Comments/Objections to Planning Application 2020/93867

Date 24th February 2020

23 Vicarage Meadow

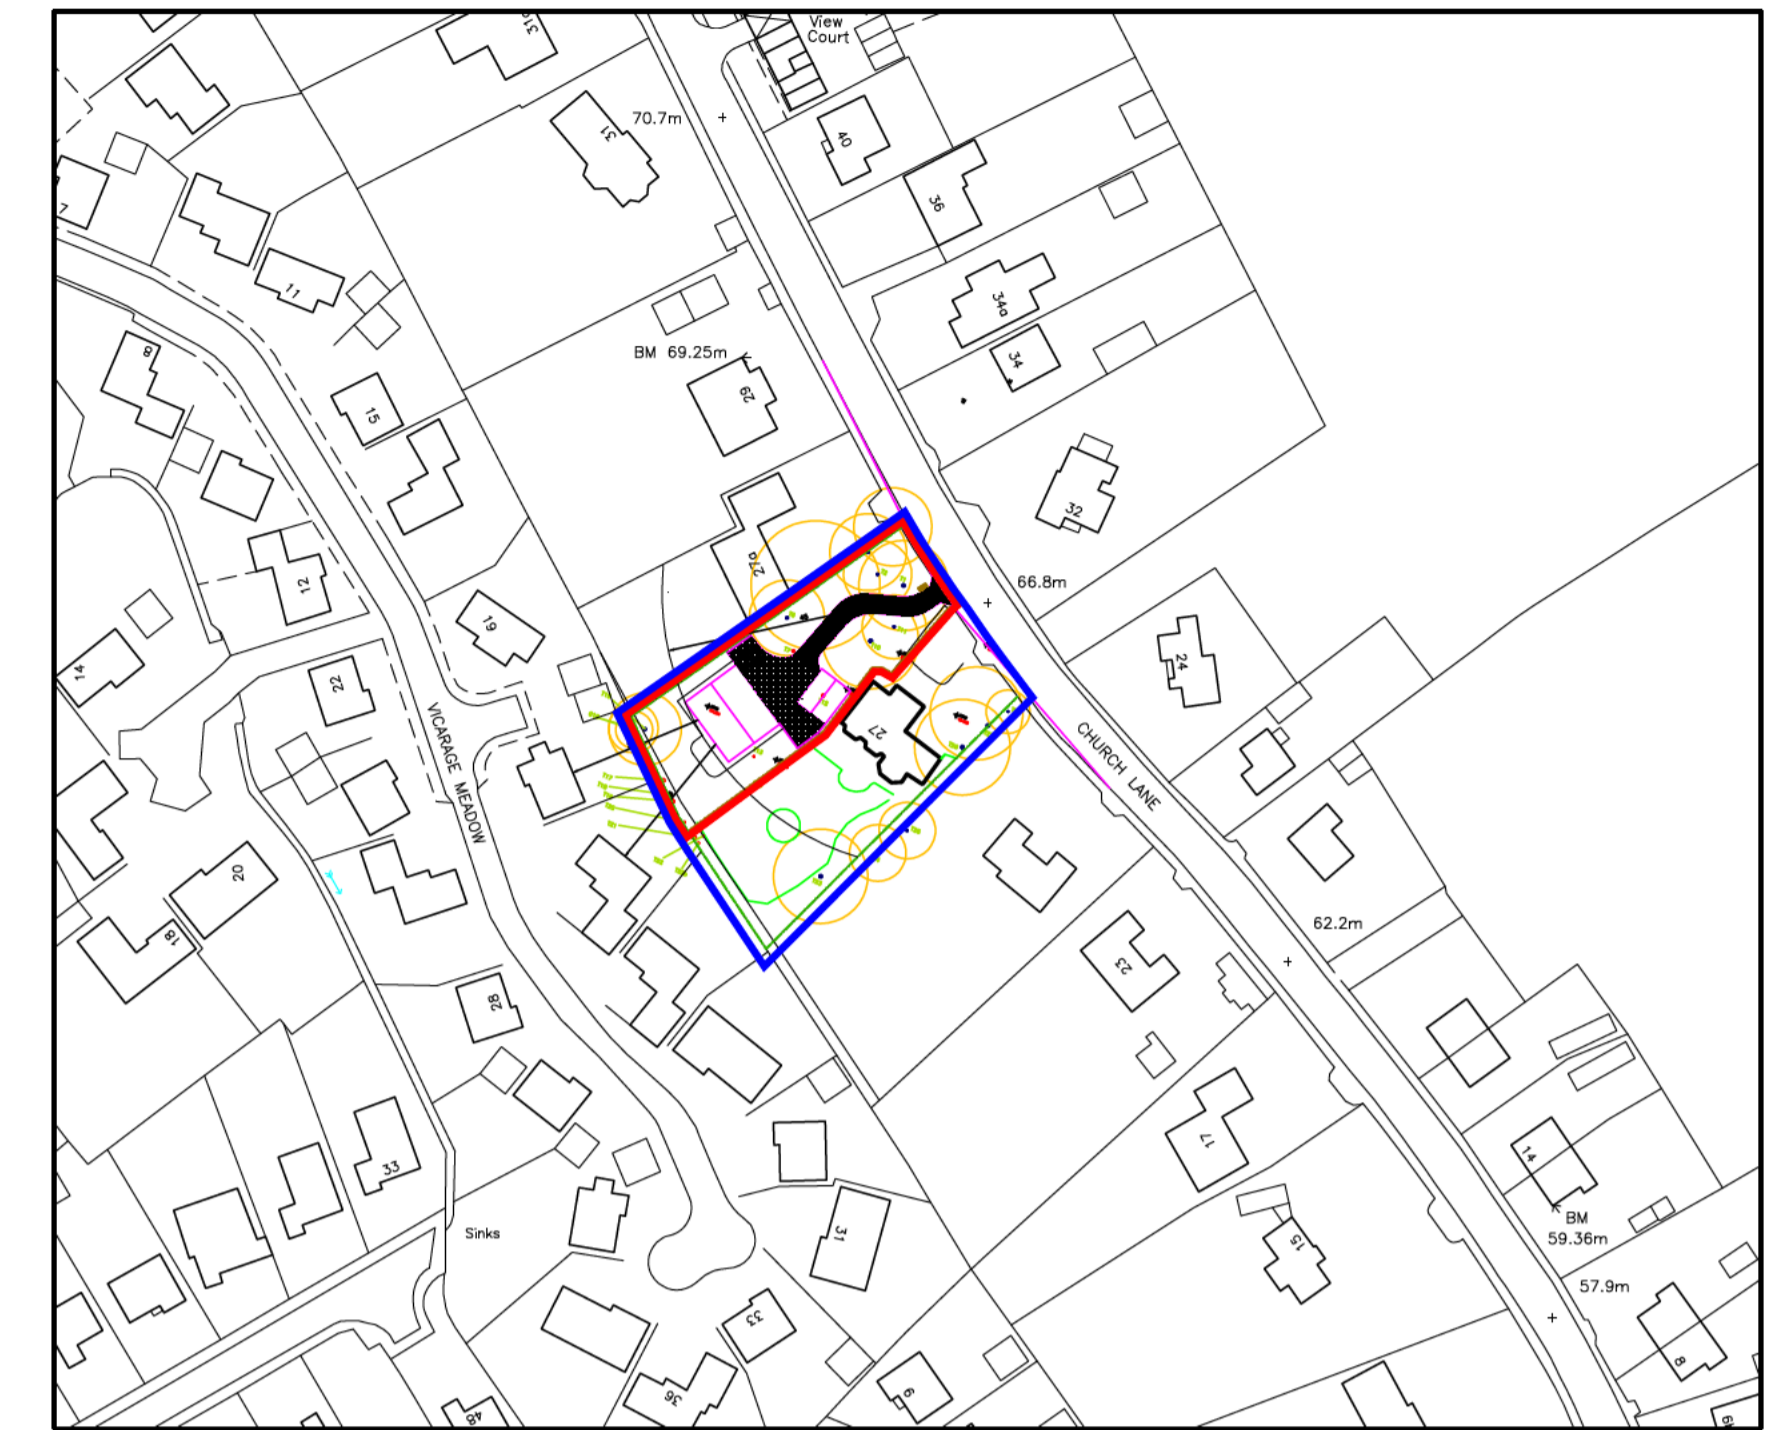
The proposed two storey detached house will be less than 23 metres from our own home. It is to be built on ground naturally sloping towards Vicarage Meadow, therefore in a significantly elevated position. This will certainly overshadow our property and will reduce the light to the back of our house. More importantly though, is the fact that four bedrooms of our house will face the new house. Due to the proximity of the new build coupled with its higher elevation will mean that our privacy will be severely affected in that the new property would overlook the rear of our house, the garden and the patio. On the other 'side of the coin' will the occupants of the new build, want us staring into their home from our bedroom windows!

The land slopes onto Vicarage Meadow, and so far, we have had no issues with surface water. Of concern is the fact that a large proportion of the land (on the slope) will be built upon, thus significantly reducing the available land for the surface water to drain. We appreciate that a soak-away is to be built, but the water still has to drain away somewhere, eventually.

The regulations state that "a rainwater soak-away must be located at least five metres from the wall of a building and at least two and a half metres from a boundary". On this basis the soak-away will

be very close to the boundary with our house and our neighbour's, where presumably the water will eventually drain.
